Development Control
Ribble Valley Borough Council

Re: Planning Application 19/1120

Address: Banks Cottage Chipping Road Longridge PR3 2NB

Description: Formation of new vehicular access drive, stone garden wall and (vehicular and pedestrian) gates to replace the existing drive. Formation of new detached garage workshop and garden store. Remodel and resurfacing of the existing site to improve vehicle access, parking and manoeuvring.

PROPOSED GARAGE/ WORKSHOP: FLOOR PLAN & ELEVATIONS

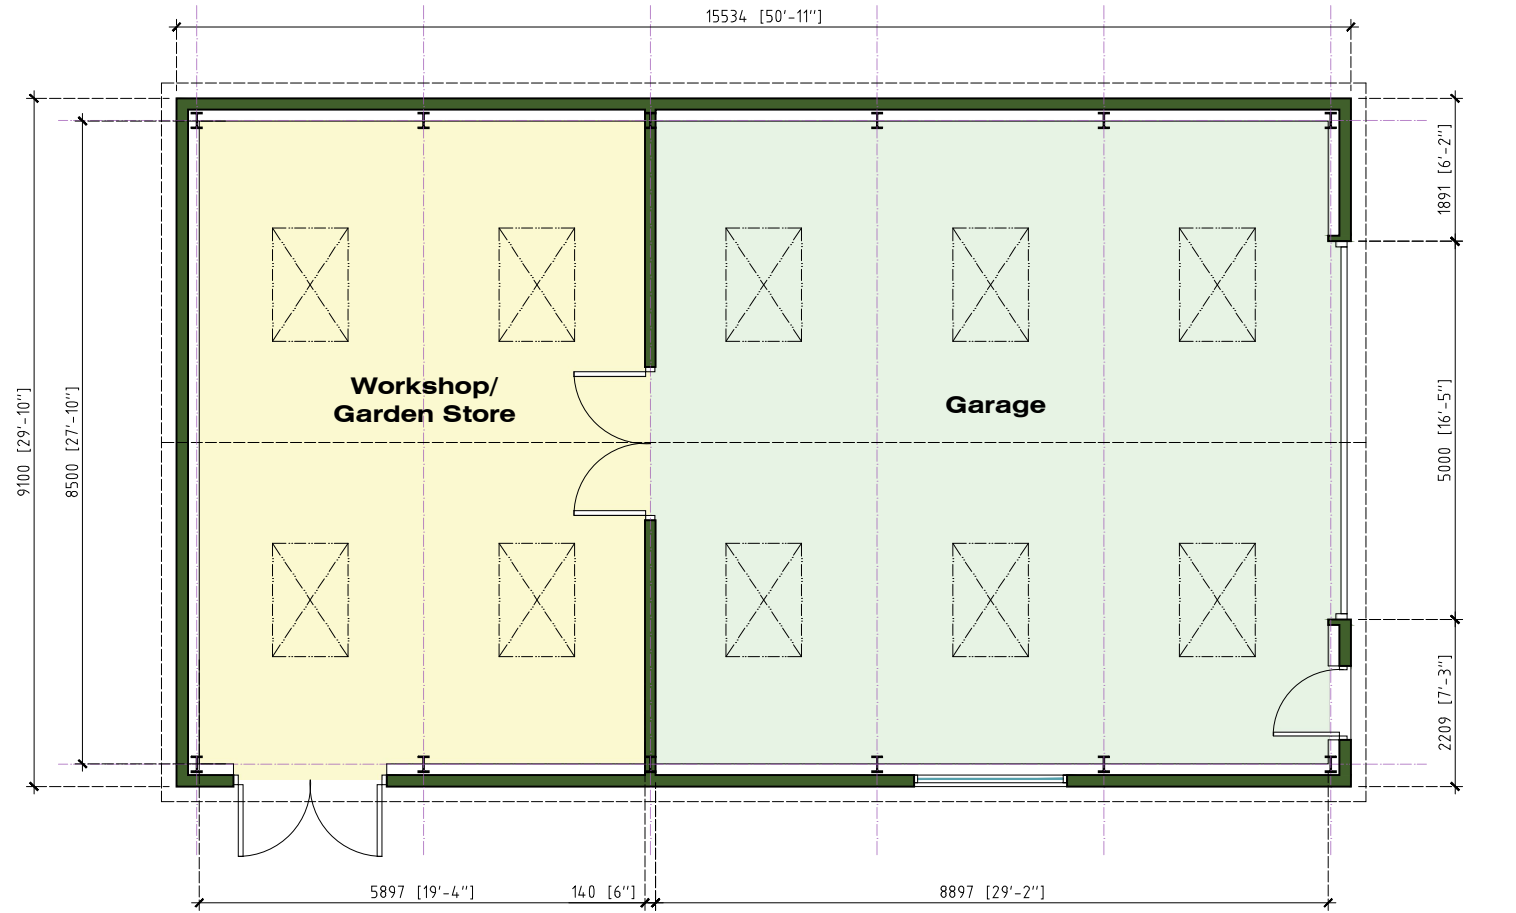
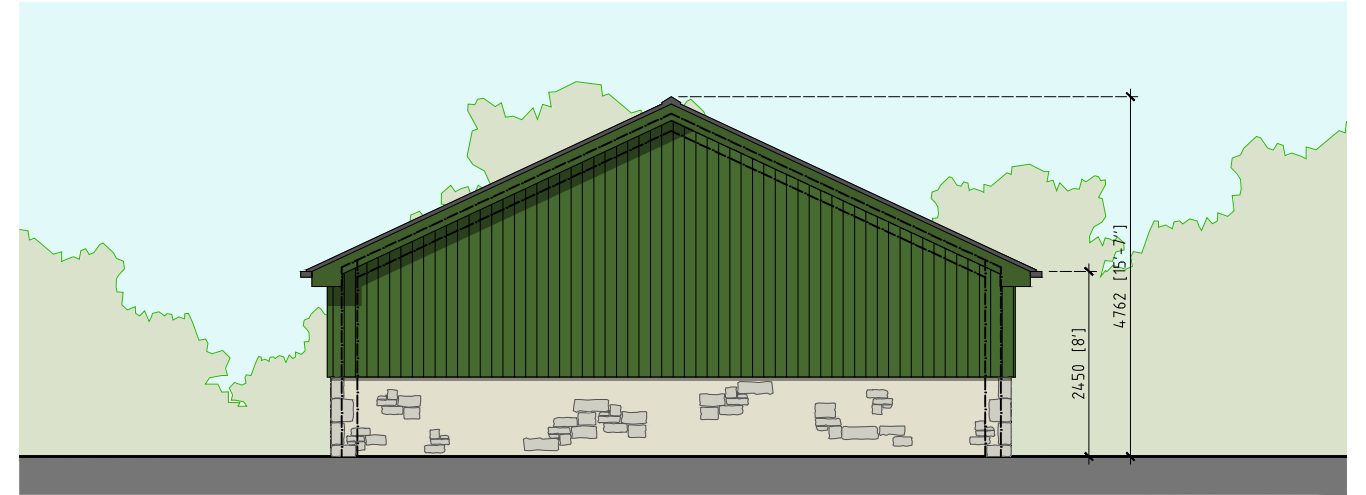
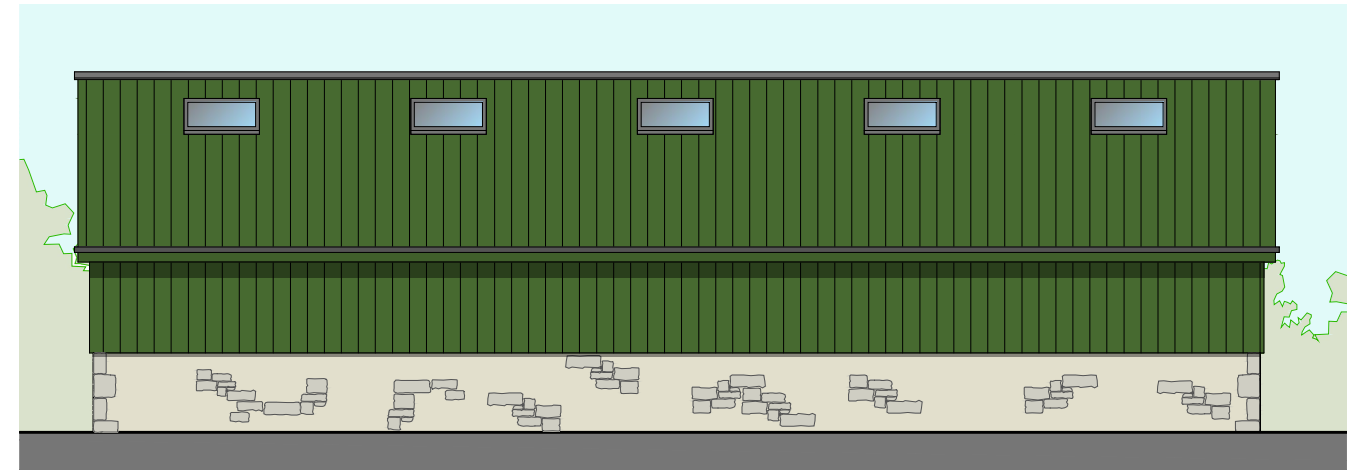
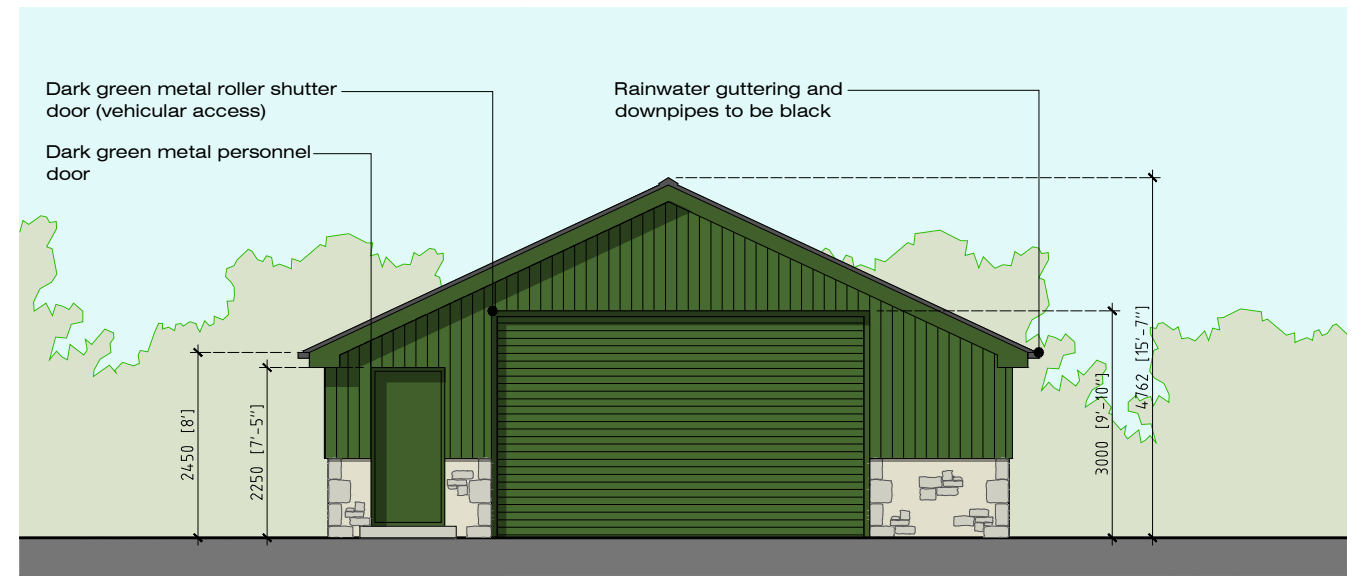
It is assumed, as there is no information to the contrary, that this garage is to be used as a private storage/workshop facility. If this is to be commercial enterprise then we would not support the access as it is proposed, but look for a further improvement in the visibility splay and the ability to allow two vehicles to pass at the entrance.

PROPOSED SITE PLAN-1

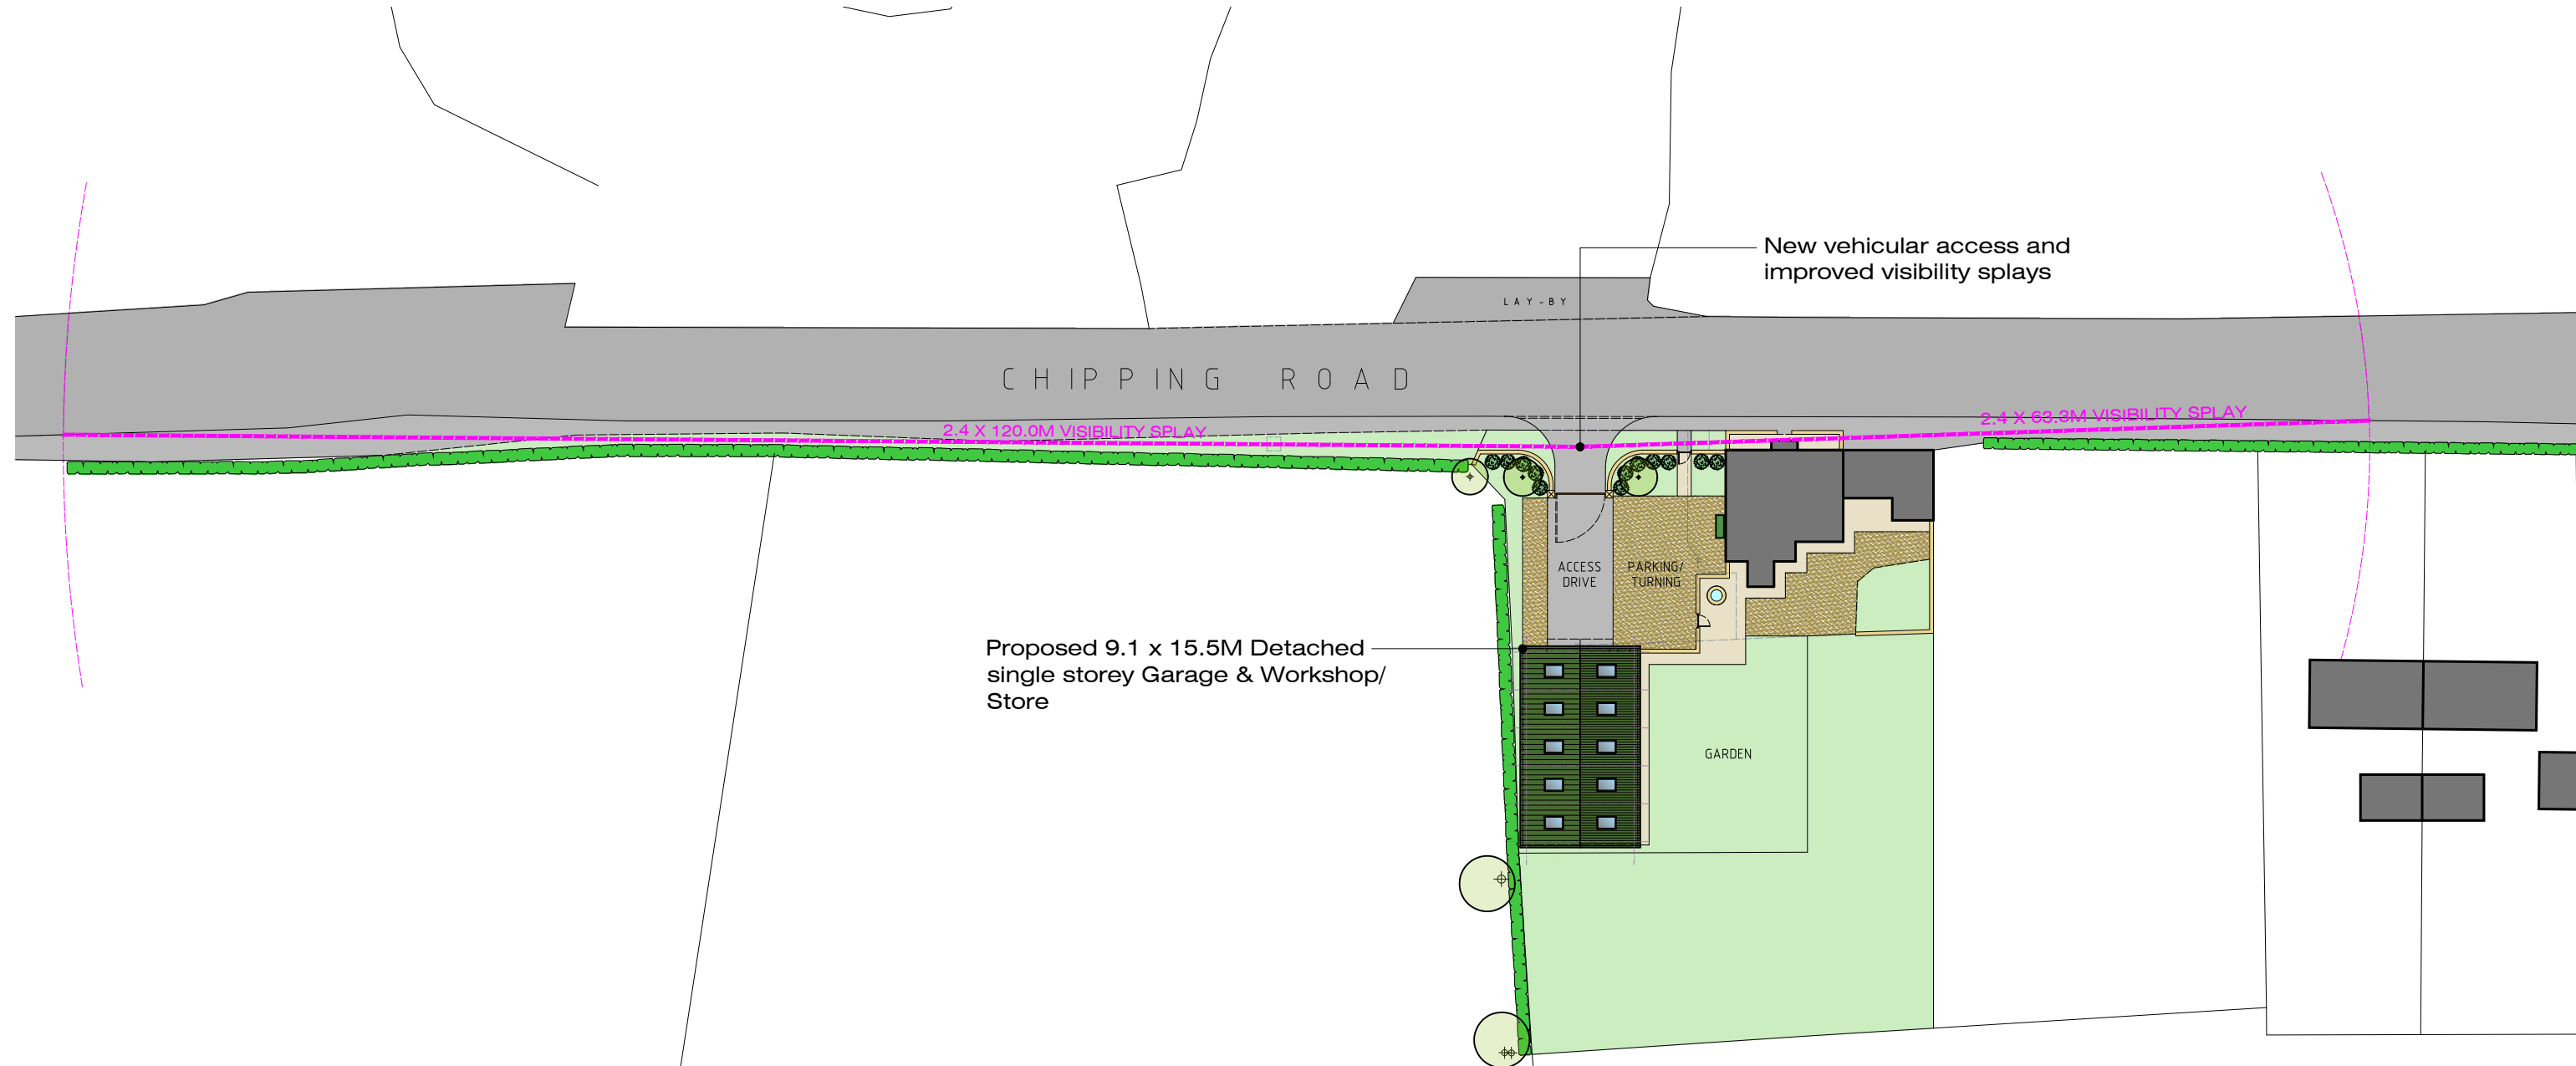
Whilst the improved visibility splays may not be to the required length as would suggested by the anticipated speed of the passing traffic, they are an improvement on the existing situation. As far as we are aware there have been no reported collisions in the area in the last five years.

1. Before the access is used for vehicular purposes, any gateposts erected at the access shall be positioned more than 5m behind the back edge of the carriageway. The gates shall open away from the highway. **Reasons:** To permit vehicles to pull clear of the carriageway when entering and exiting the site and to ensure the swing of the gates do not affect the availability for a car to wait off road.

5. Before the access is used for vehicular purposes, that part of the access extending from the highway boundary for a minimum distance of 5m into the site shall be appropriately paved in tarmacadam, concrete, block paviments, or other approved materials. **Reasons:** To prevent loose surface material from being carried on to the public highway thus causing a potential source of danger to other road users
